KITTITAS COUNTY COMMUNITY DEVELOPMENT SERVICES

RE: Keno Short Plat (SP-18-00006) - Determination of Incomplete Application

KENO AGRICULTURAL SHORT PLAT  
PART OF SECTION 29, T. 18 N., R. 20 E., W.M.  
KITTITAS COUNTY, WASHINGTON

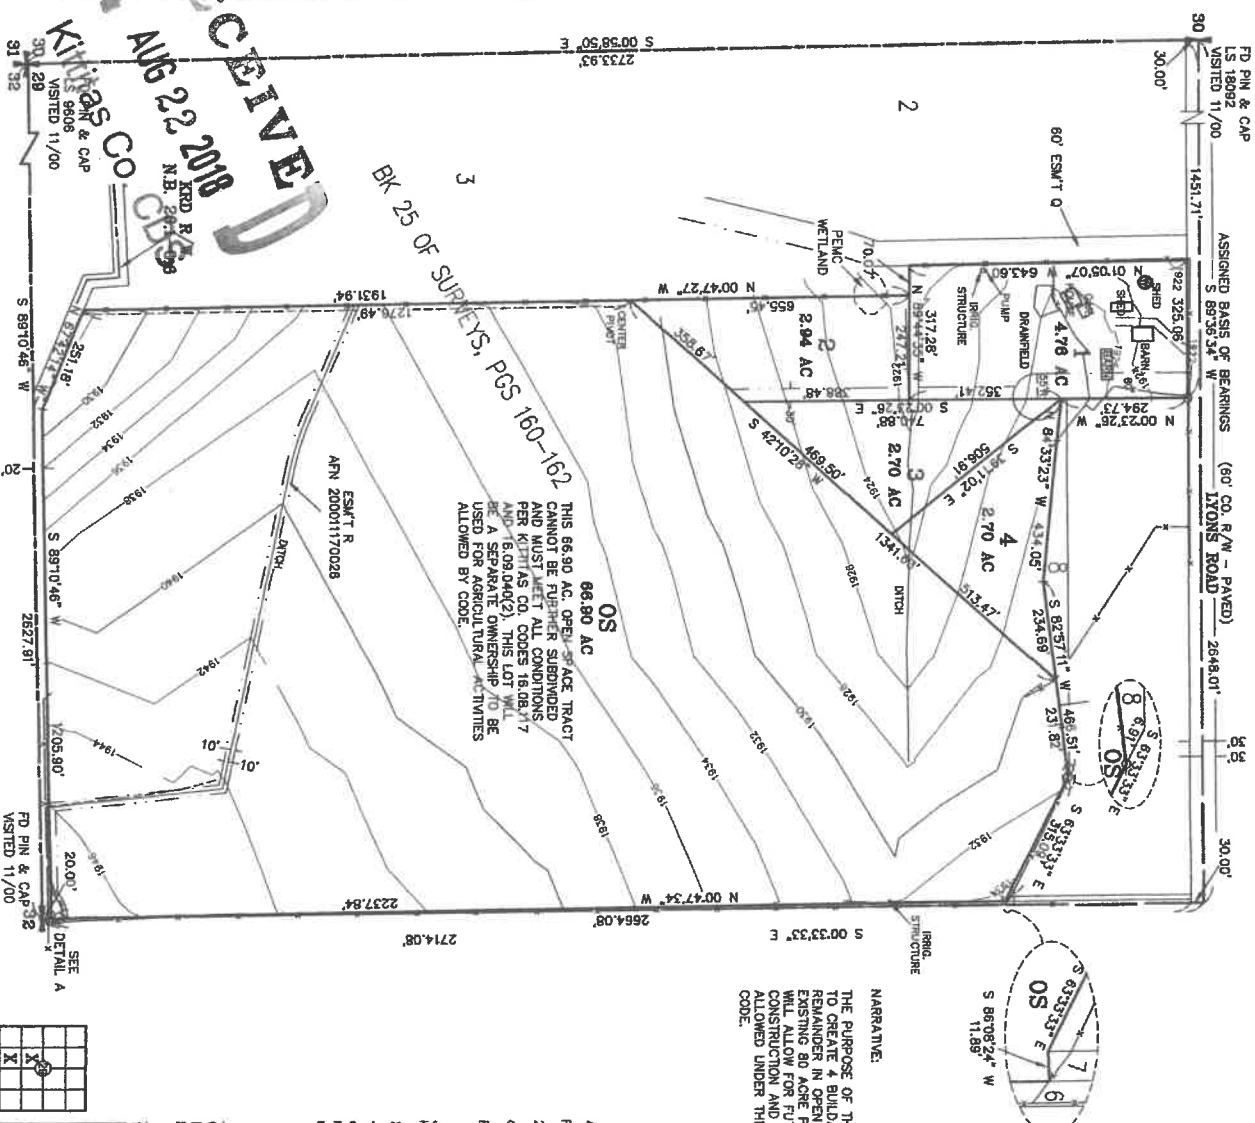
Determination of Incompleteness: This determination is based on the number of lots proposed in your application. During a preliminary code compliance review of your application, CDS determined that the proposal would result in 5 lots as "lots" are defined in KCC 17.08.360. An agricultural short plat is limited to 4 lots.

Required Information: Before staff can continue review of your application, one of two changes must be made.

- 1) A new site plan or survey must be resubmitted to our office demonstrating that at least one lot has been removed, resulting in no more than 4 lots; or
- 2) CDS can continue processing your application materials as a long plat instead of a short plat. This would require a long plat application to be submitted along with a SEPA checklist. Currently the fee difference would be \$3,354 for the long plat application. The SEPA fee is indicated on the SEPA checklist application. Please double check with our permit technicians to ensure this still reflects the current fee schedule at the time of submittal.
